From: Richard Temple
Sent: 07 February 2018 10:38
To: 'BRYAN BUTCHER'
Subject: RE: 31, Frith Road, Bognor Regis - BR/133/17/HH

From: BRYAN BUTCHER [REDACTED]
Sent: 01 February 2018 09:16
To: Richard Temple
Subject: 31, Frith Road, Bognor Regis - BR/133/17/HH

PROPOSED BOUNDARY FENCE AT 31 FRITH ROAD, BOGNOR REGIS
FOR MR. & MRS. J. CIOK.

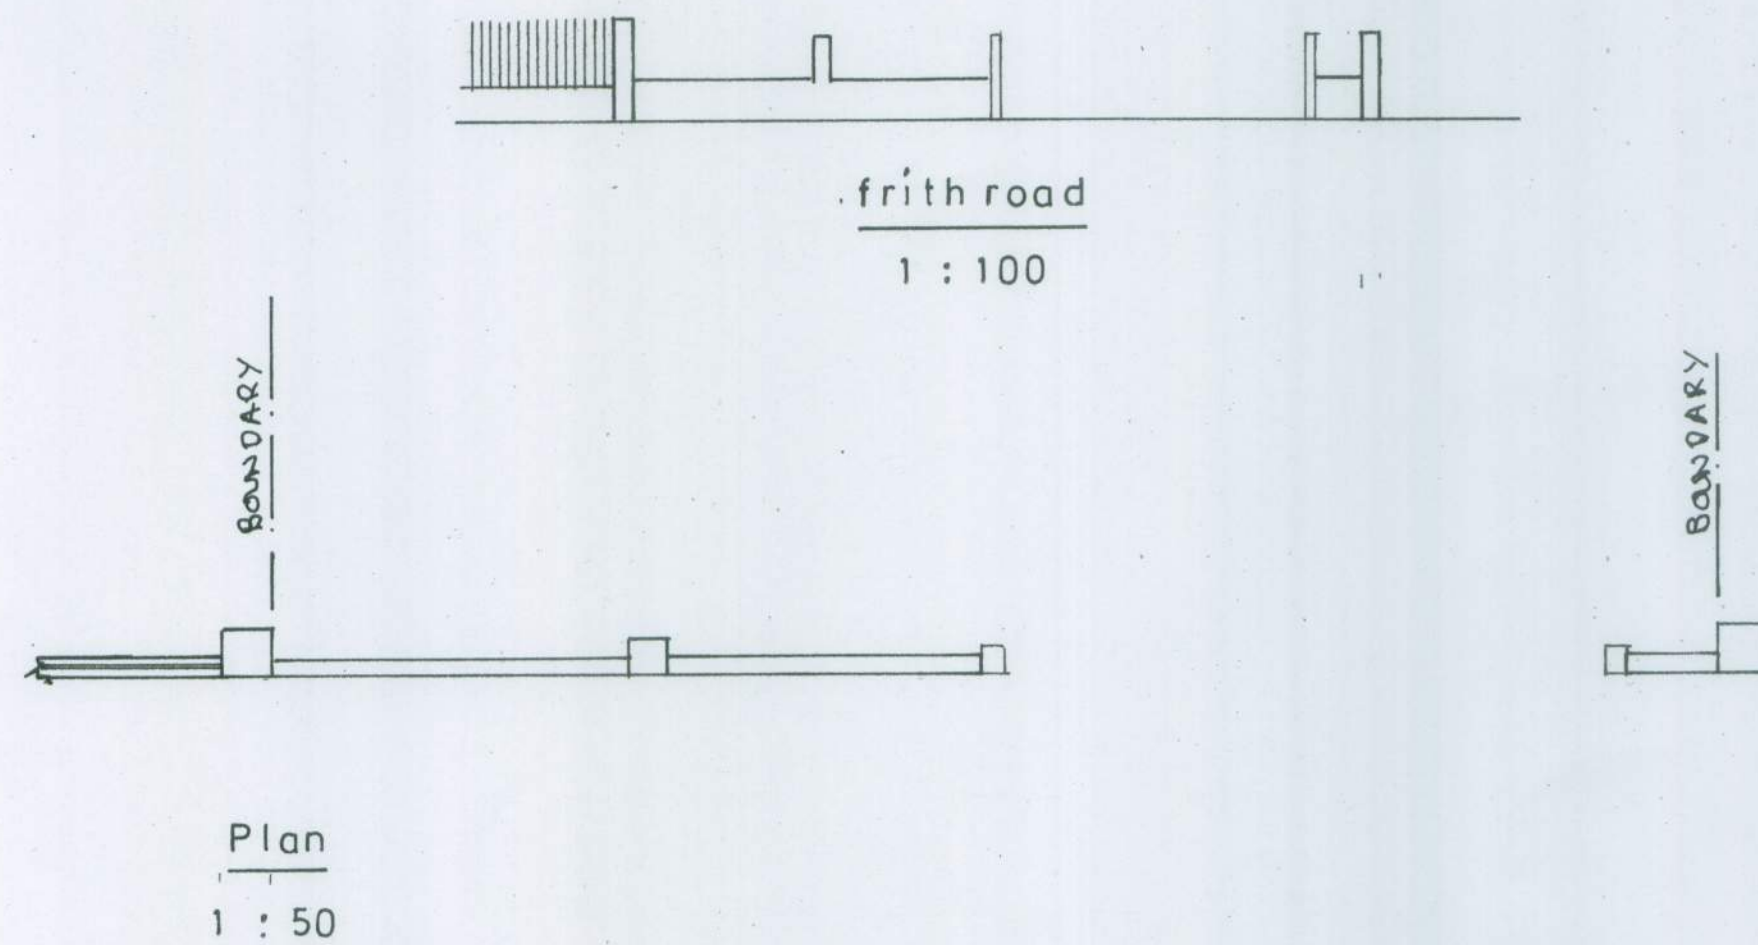
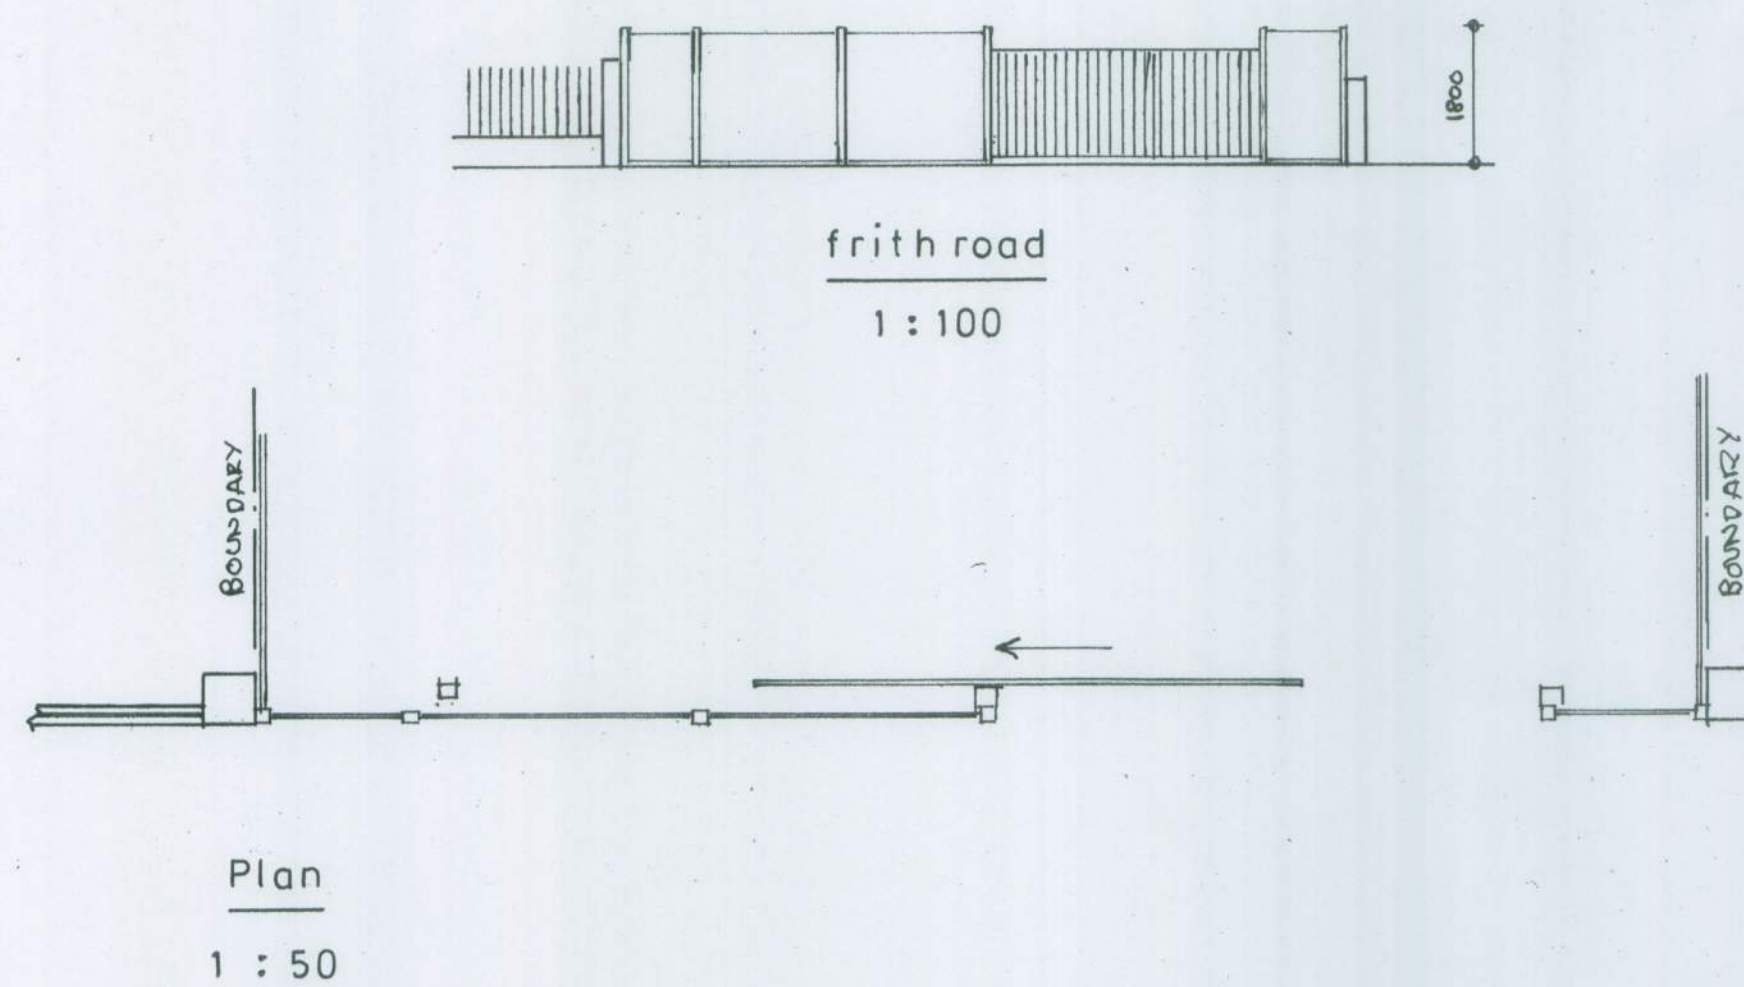
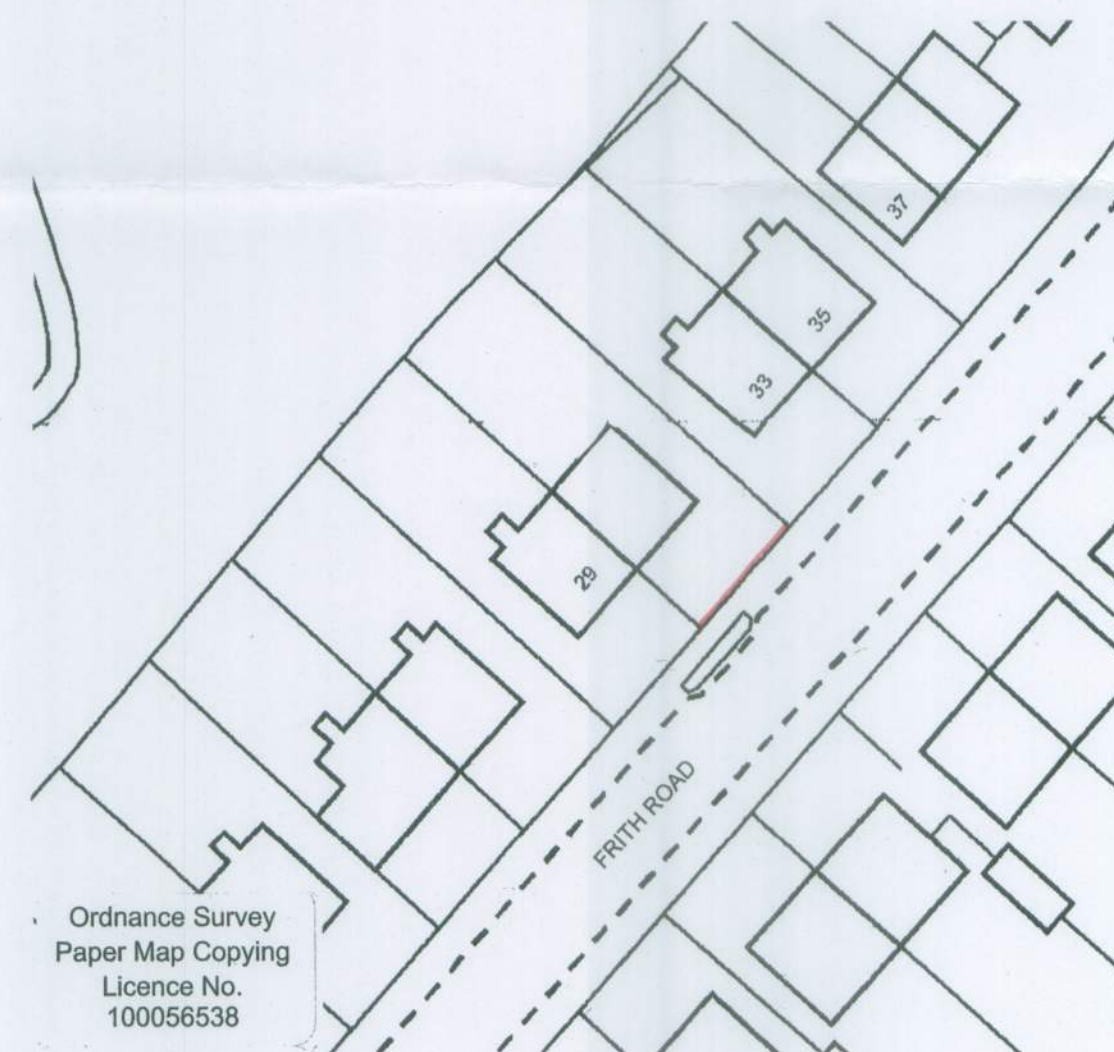
My client has asked whether there is a height of boundary detail between 1000 and 1800mm that you would feel is acceptable?

1m would not require formal planning consent. Anything solid in nature above that height is unlikely to be acceptable.
